KITITITAS COUNTY

MEMORANDUM

TO: All Staff
FROM: Public Works Plan Review Team
DATE: August 7, 2025
SUBJECT: LP-25-00004 Pfenning Road

SHEET NAME
PRELIMINARY PLAT

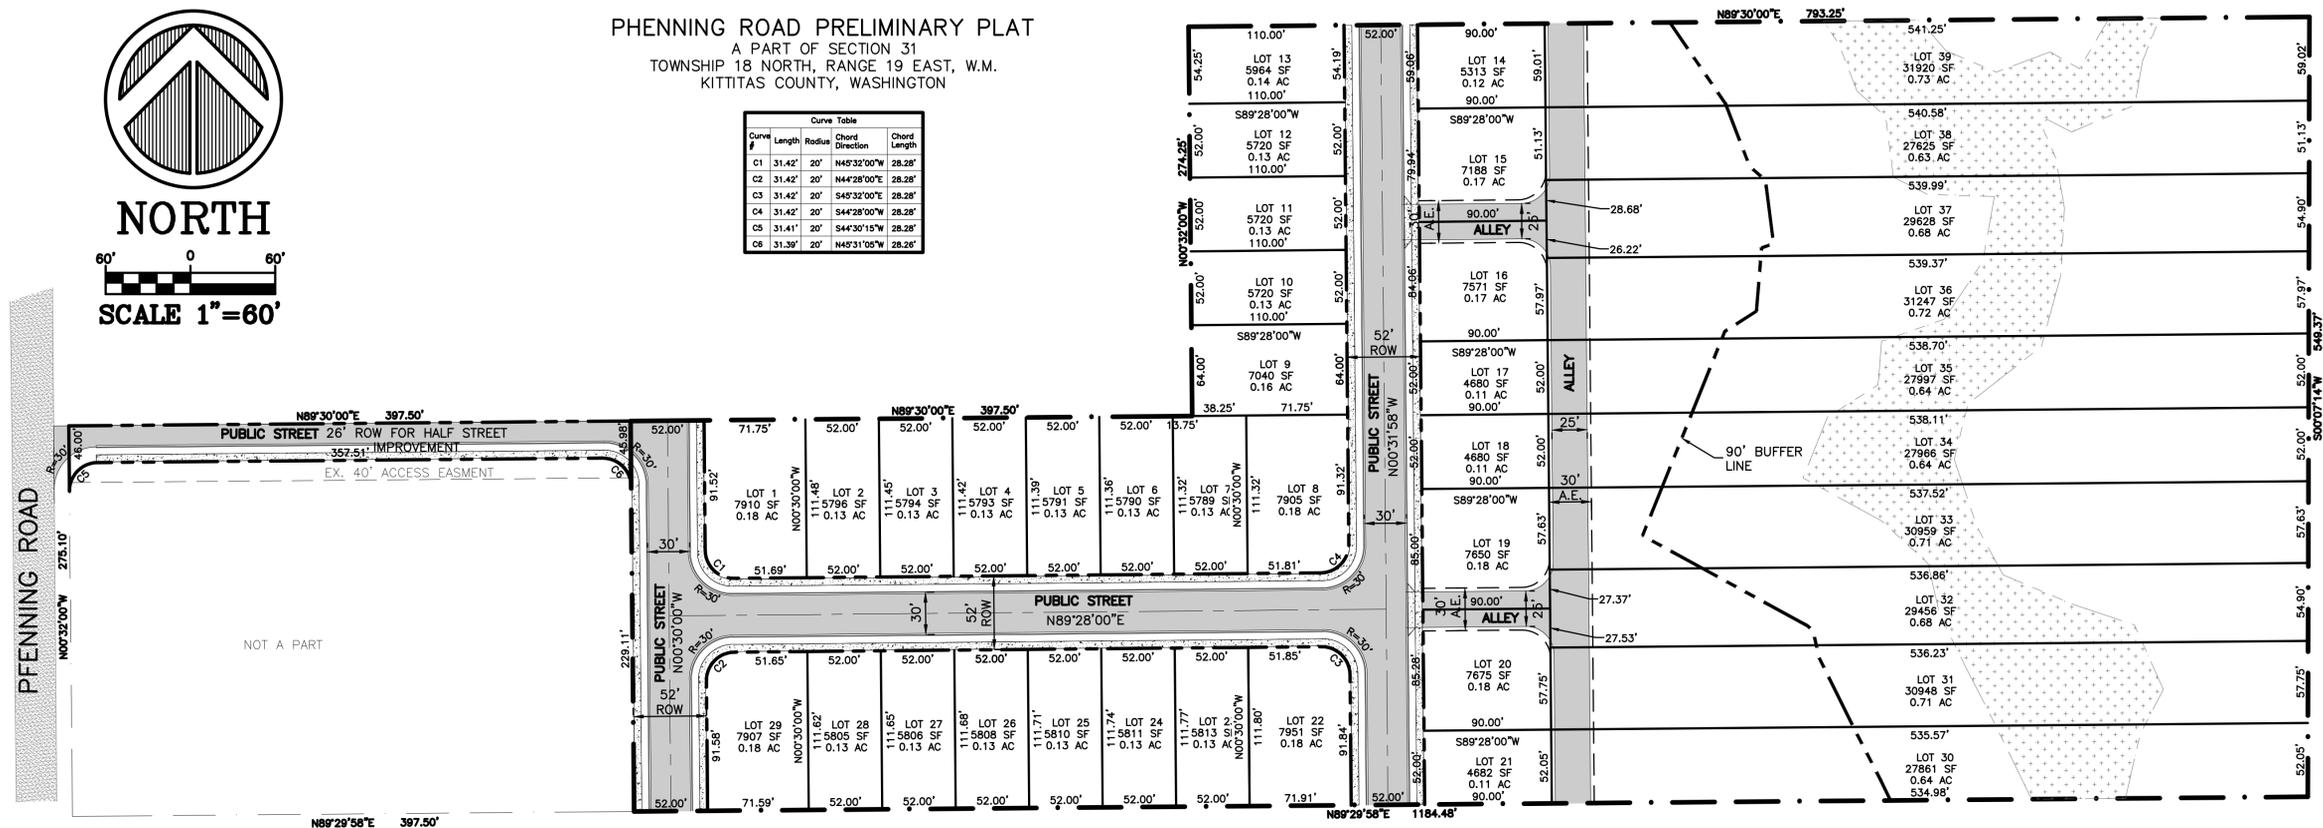
ACCESS	<p>Kittitas County Code 12.07 requires use of City of Ellensburg standards for roadways, sidewalk, curb, and gutter pursuant to Ellensburg City Code Title 4.</p> <ol style="list-style-type: none"> 1. Road's serving development shall be named per City of Ellensburg standards. 2. Maintenance of driveway approaches shall be the responsibility of the owner whose property they serve. The County will not maintain accesses. 3. Any further subdivision or lots to be served by proposed access may result in further access requirements. (RC)
ENGINEERING	<ol style="list-style-type: none"> 1. Per the Kittitas County and City of Ellensburg Interlocal agreement the roads and road standards for this project shall be per the City of Ellensburg standards and is subject to review by the City of Ellensburg. 2. If the parcels associated with this plat are not annexed by the City of Ellensburg then the roads within the plat will need to certified as private roads. 3. Except as exempted in KCC 14.05.060, no grading or filling upon a site involving more than one hundred (100) cubic yards shall be performed without a grading permit from the County Engineer or Public Works designee (KCC 14.05.050). An application for grading in excess of five hundred (500) cubic yards shall be accompanied by an engineered grading plan (KCC 14.05.080). This grading plan will be under a joint review with the City of Ellensburg. (CBP)

SURVEY	<p>1. Kittitas County Code 16.24.010(1) reads as follows: The survey of every proposed subdivision, boundary line adjustments, record of survey, and the preparation of preliminary and final plats thereof, shall be made by or under the supervision of a registered land surveyor who shall certify on the plat that it is a true and correct representation of the lands actually surveyed. All surveys shall conform to standard practices and principles for land surveying.</p> <p>No further review will be made until the proposed Long Plat contains a stamp of a Land Surveyor licensed to practice in Washington state. (JT)</p>
